**Consultation Response from KC,
Highways Development Management**

2024/90273 adj, 53, Garden Place, Dewsbury Moor, Dewsbury, WF13 4EP

Erection of two semi detached dwellings

Date Responded: 27-2-2024.

DRAWING TITLE
Site Block Plan
REV 01

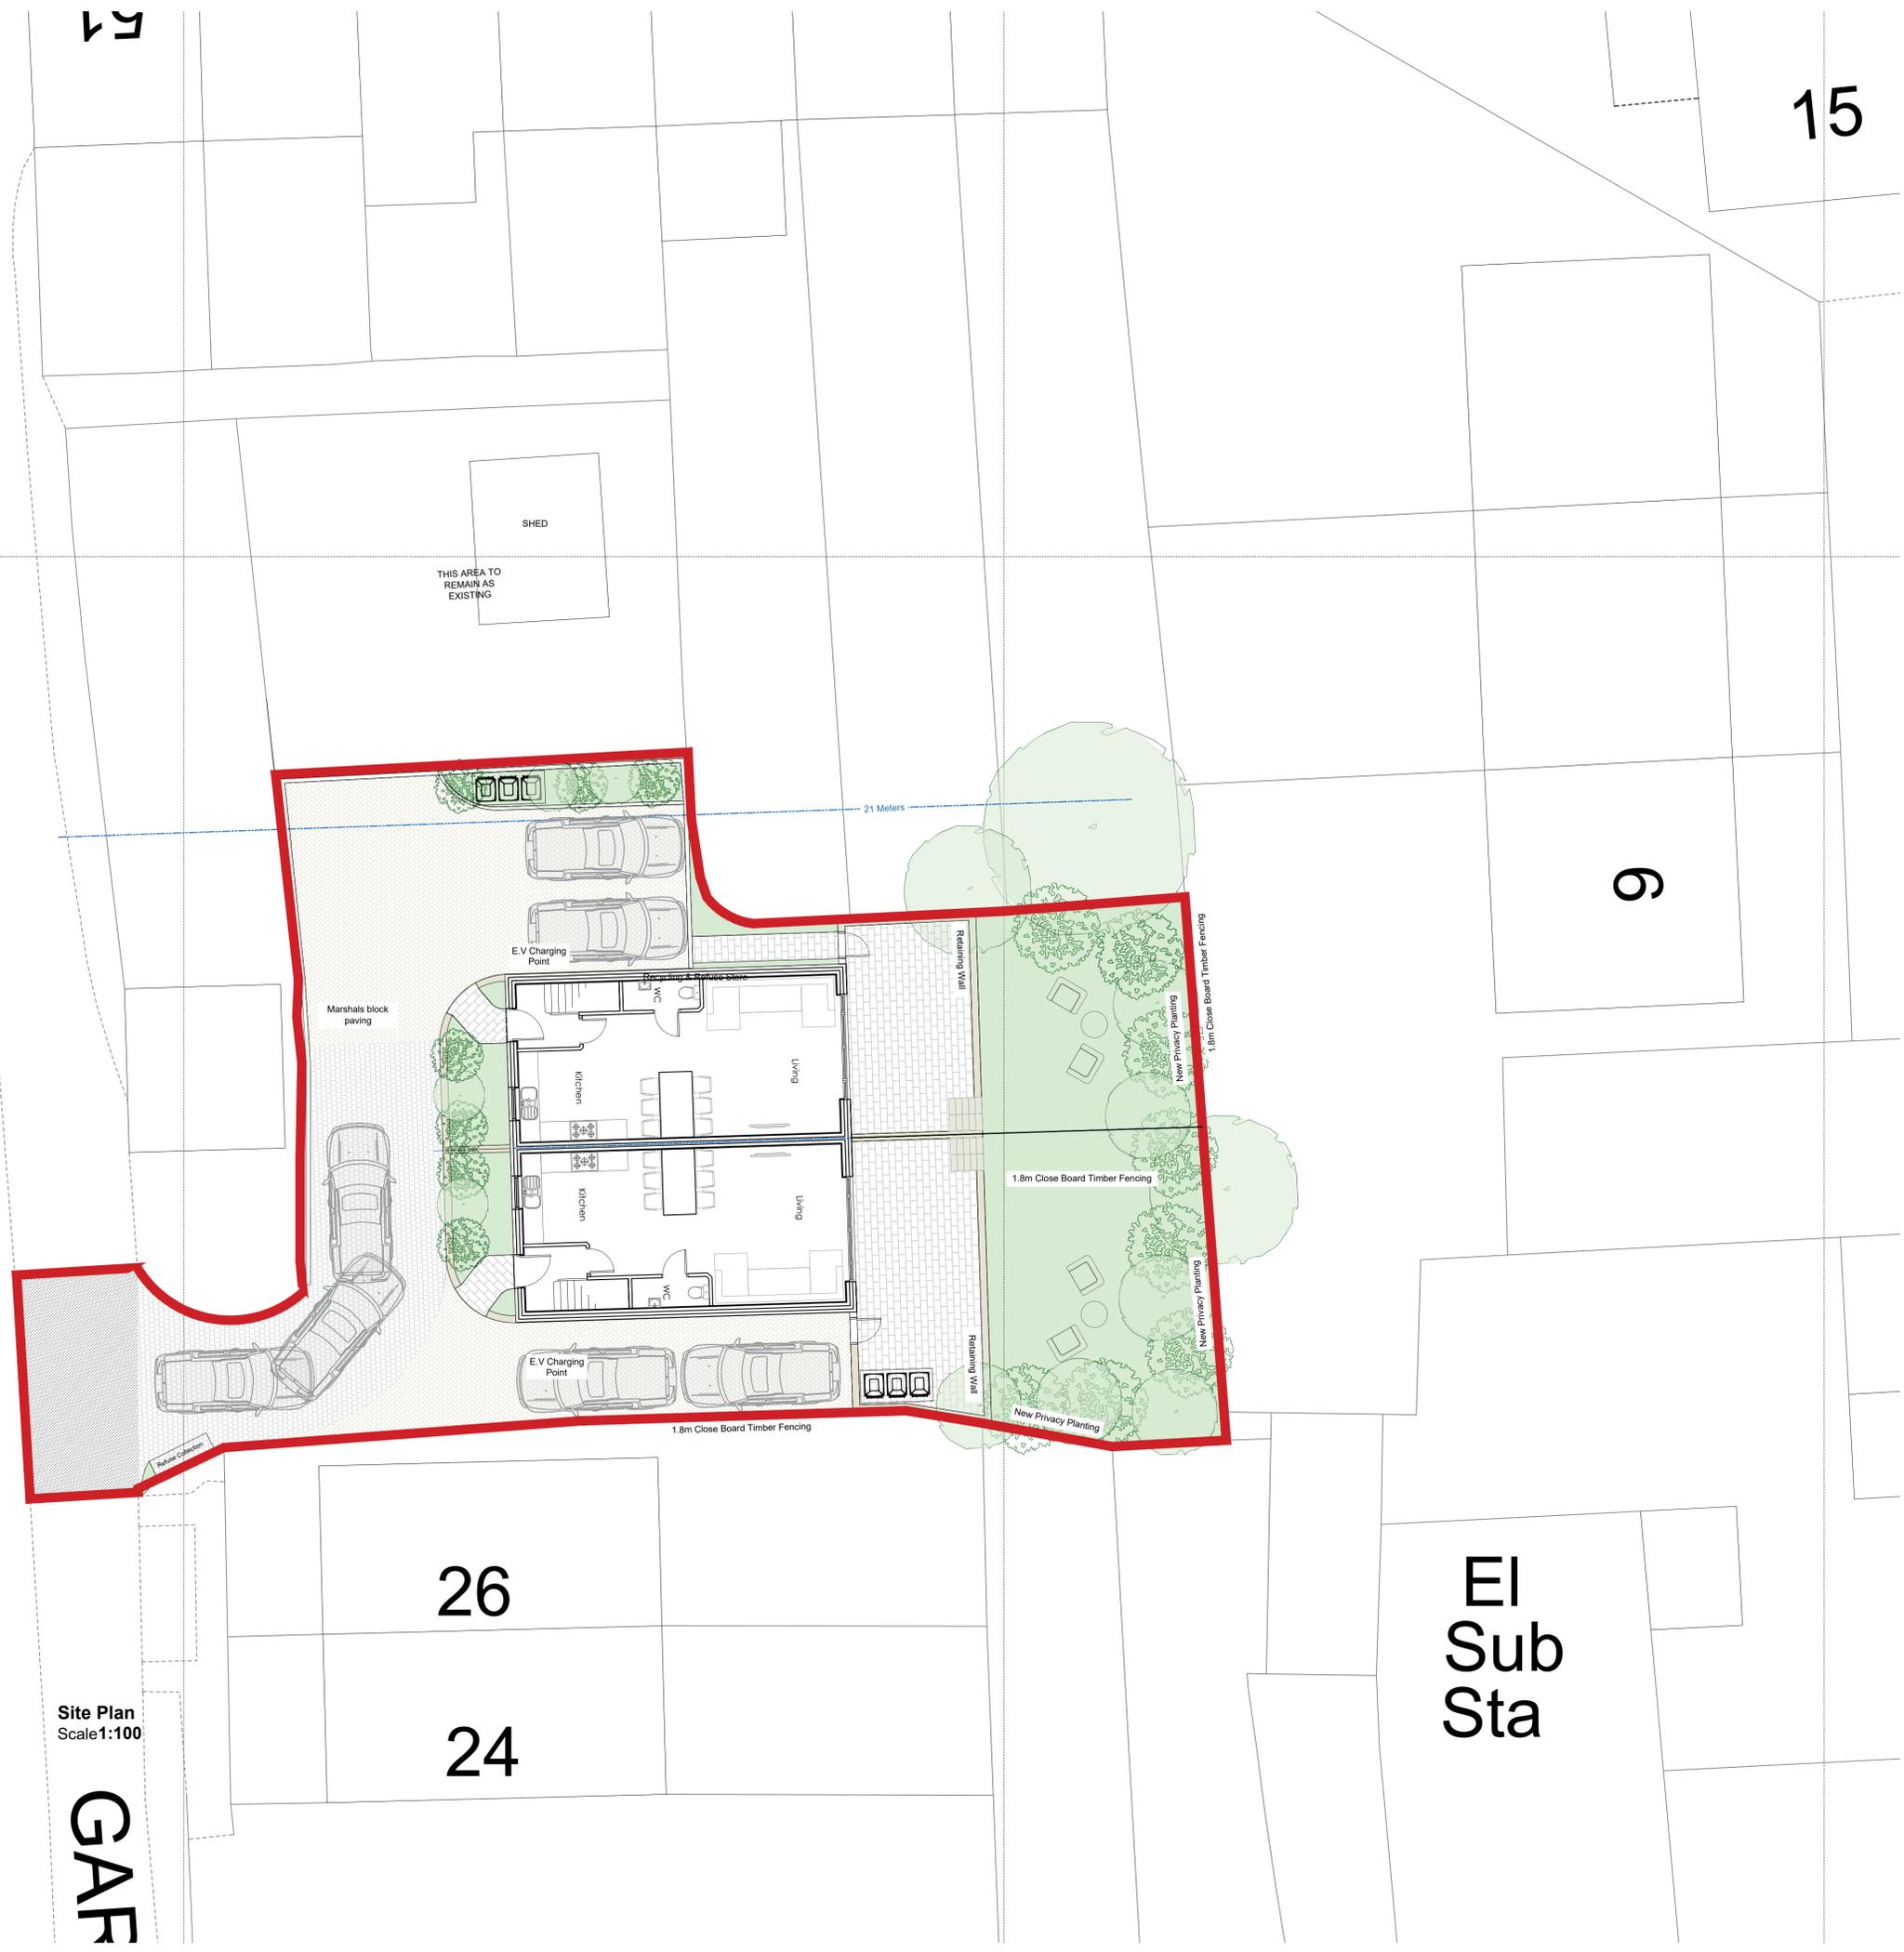
Plan number HA-23-08-04 (Site Block Plan) shows a pair of semi-detached houses to the southern boundary of the site, a double garage to the northern boundary, access from Garden Place, two parking spaces with EV charging to either side of the garage, and space for internal vehicle turning between the houses and garage. A bin collection point is shown at the site entrance.

Given the previous approval and that suitable off-street parking and internal vehicle turning is shown to be provided H D M consider these proposals acceptable in principle.

The access between Church Lane and the site access should however be shown to be widened to 4m as required by condition 4 of the 2022 application.
